PROJECT #: 23-1180-A

DATE: February 19, 2024

LOCATION: Lot 54, Cotton Farm

PLANS REF: Lot 54, Cotton Farm by Murphy Garnow Design Group Project #: 23-1180

HOUSE NAME:
HOUSE NUMBER:
PAGE NUMBER:
SD

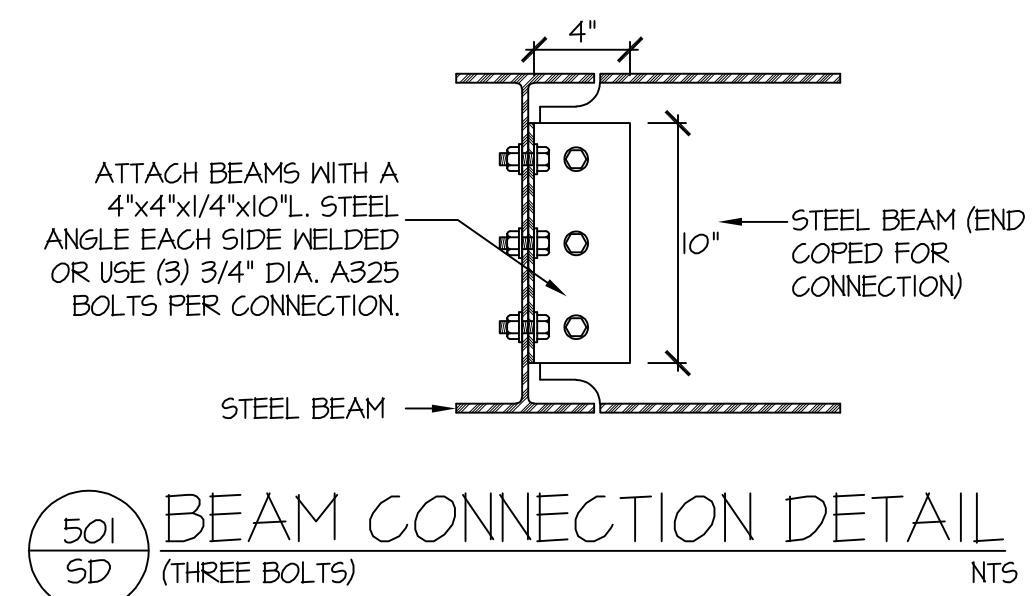
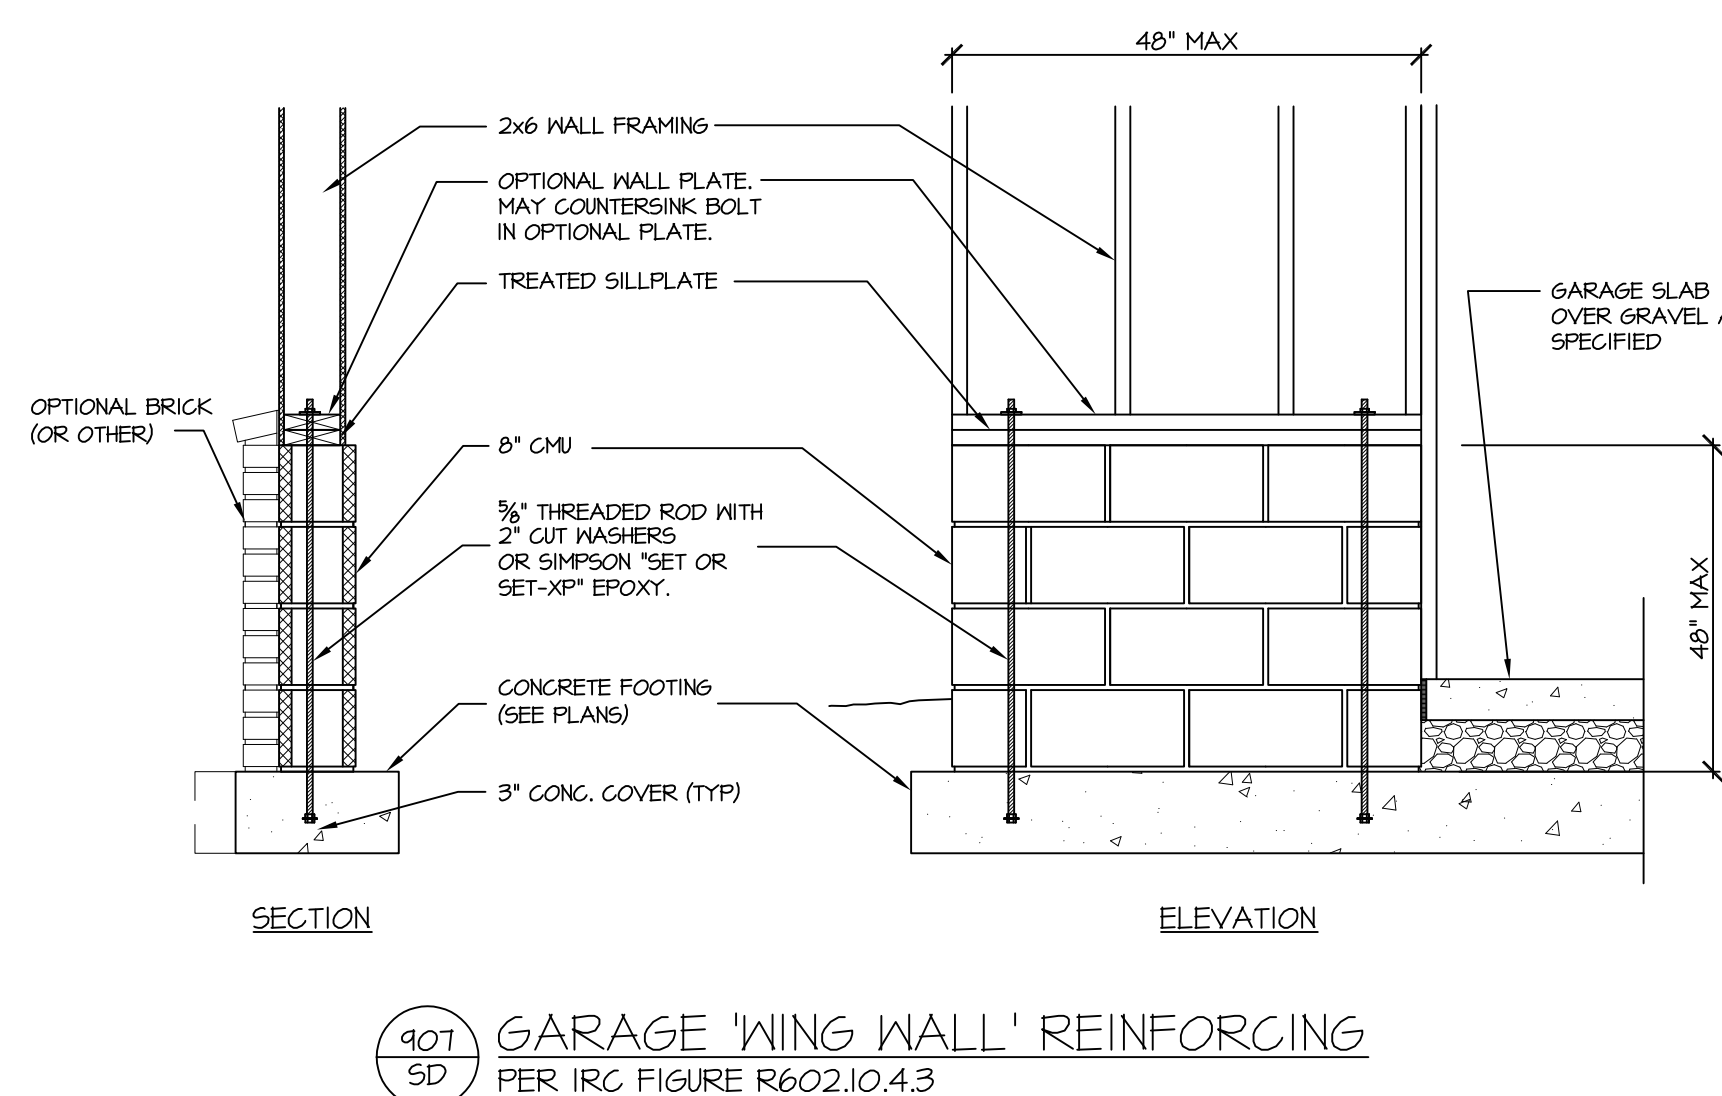
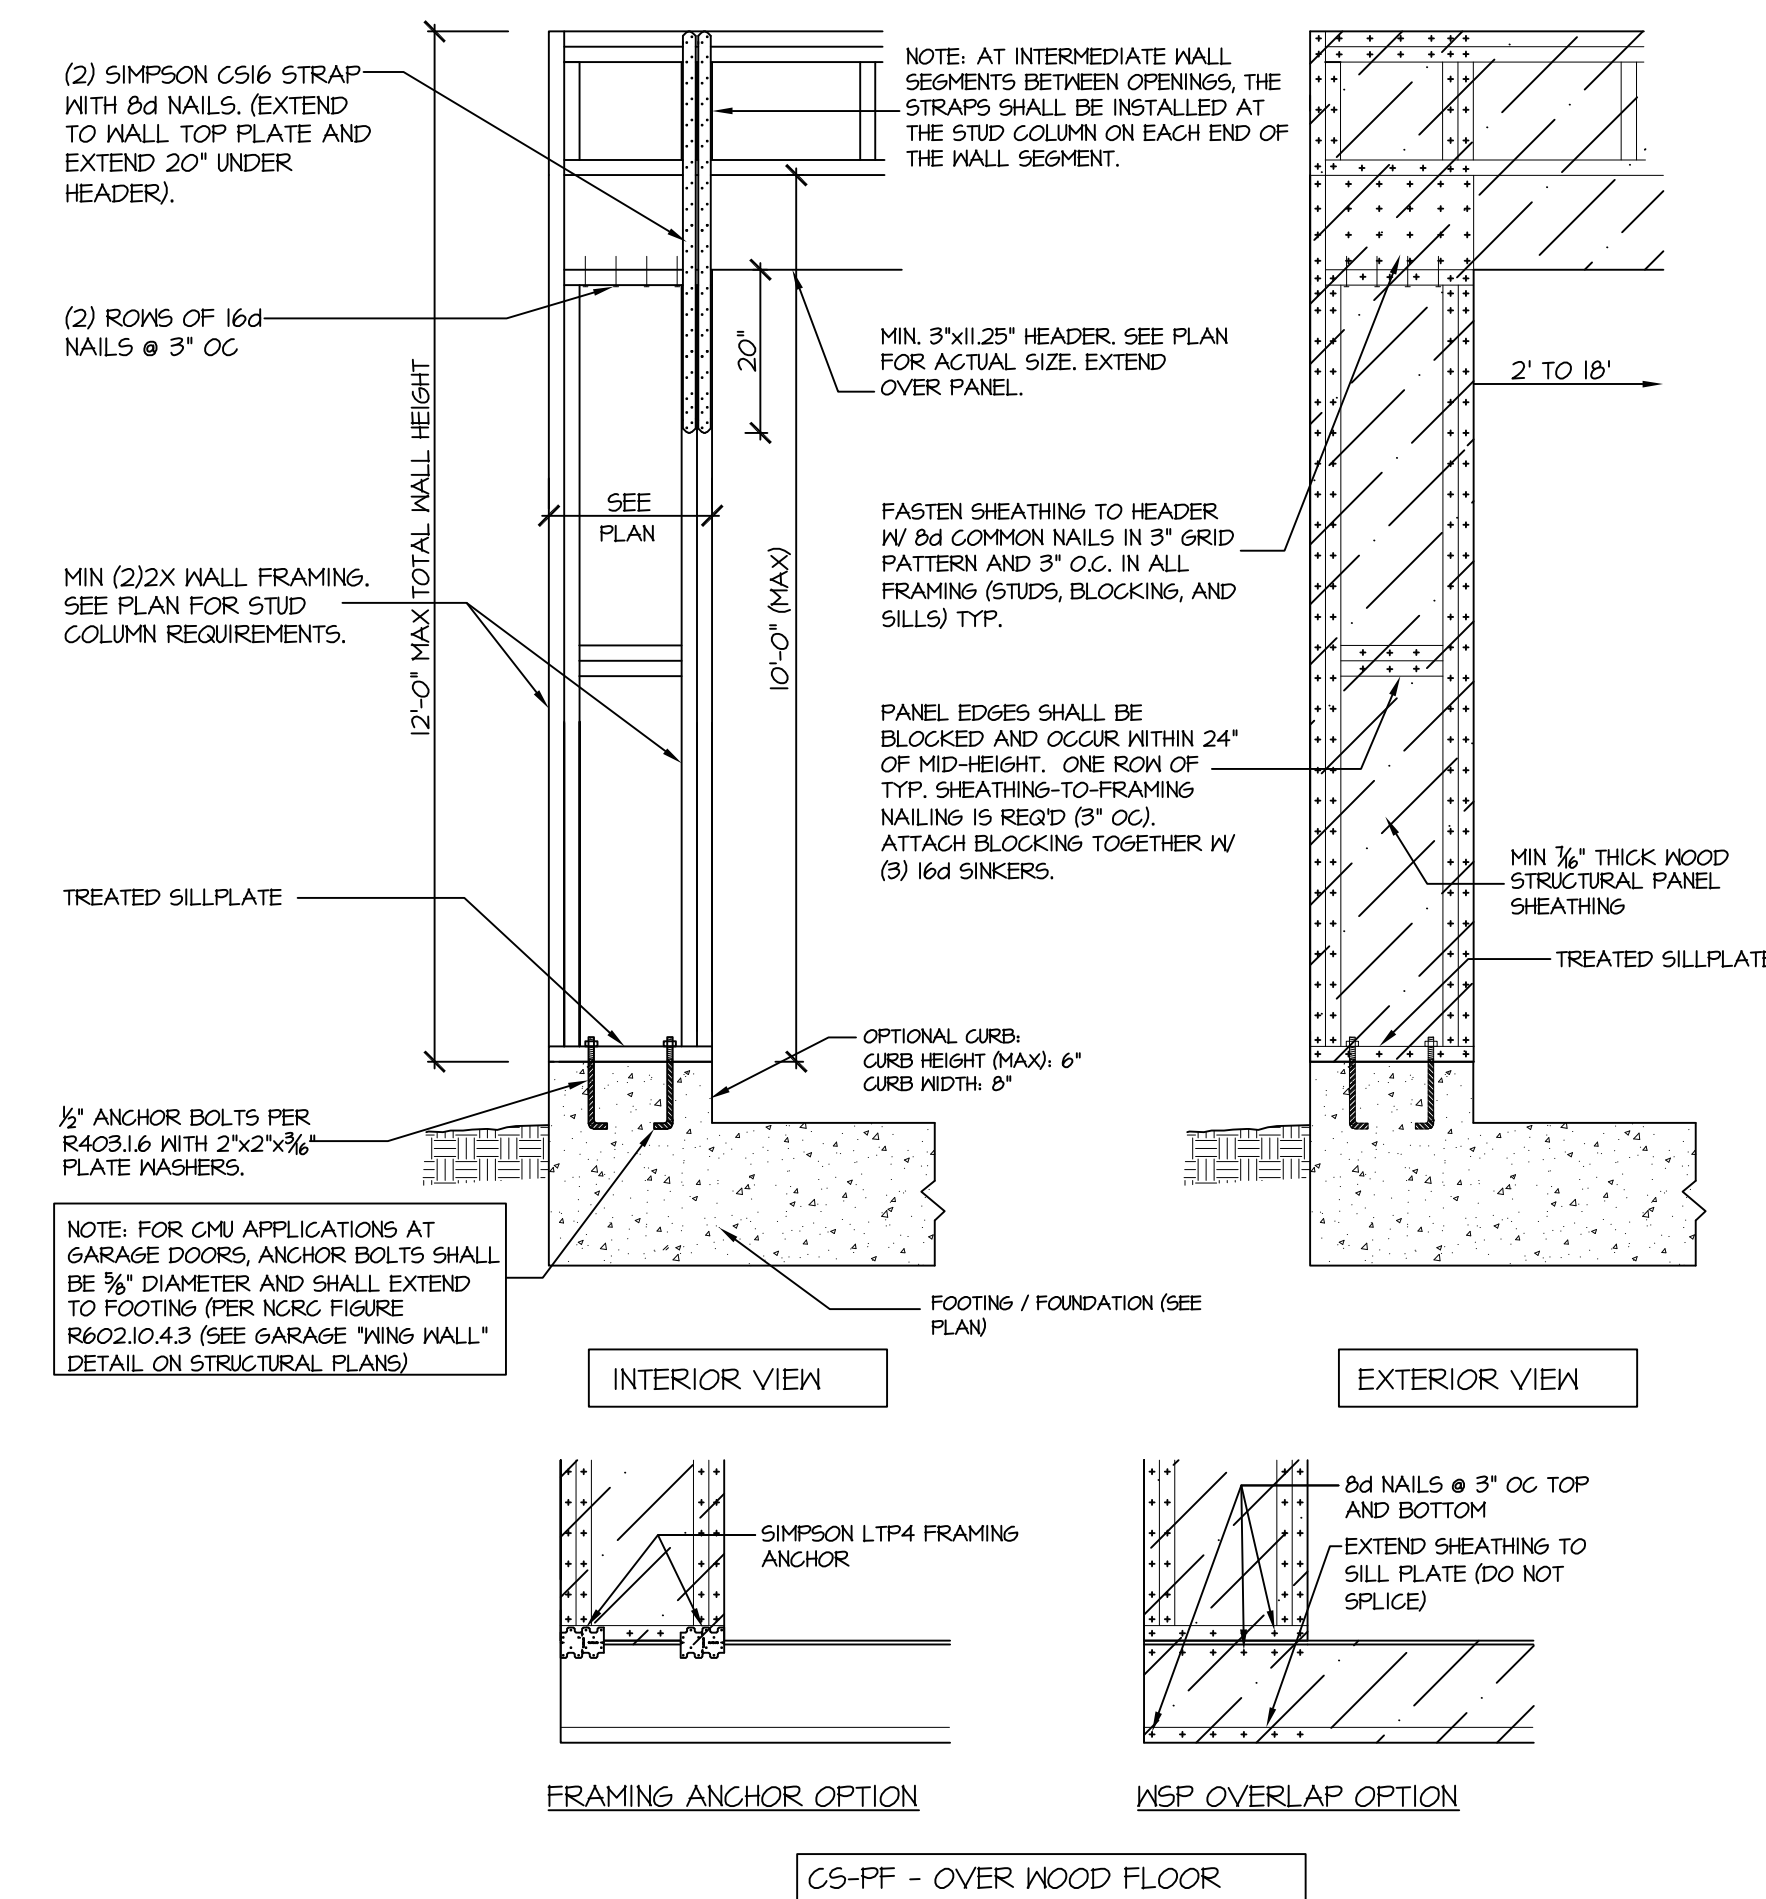
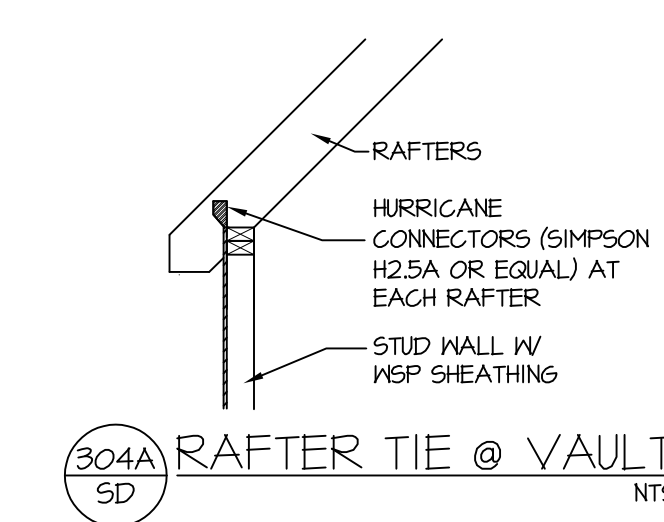
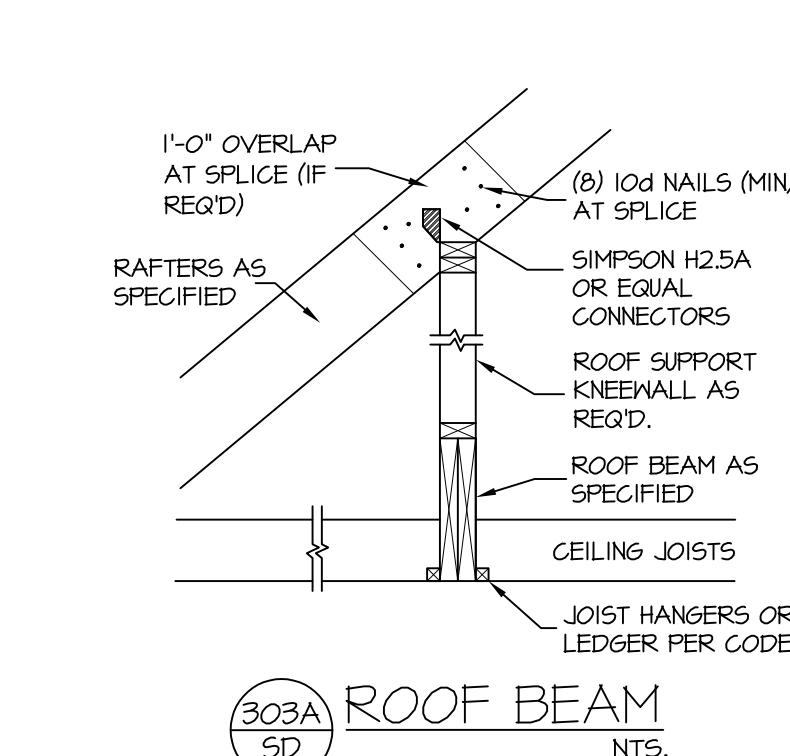
Breakfast Beam Support: Page seven of the plans shows a (3)1.75x16 LVL spanning left-to-right above the breakfast nook. The left end of the beam is shown to be supported by (7) studs with direct stud bearing under the beam per detail “206A/SD”. The right end of the beam is noted to be supported by (7) studs and to “provide 6” min bearing length for the front (2) plies of the LVL”. Based on information provided to Southern Engineers, the right end of the beam was not extend and only has 3½” of bearing length on the wall.

Response: Please note that since the right end of the beam was not extended along the wall, the top plate of the wall shall be cut out and new studs with direct bearing under the beam installed in the same manner as the left end of the beam per detail “206A/SD”.
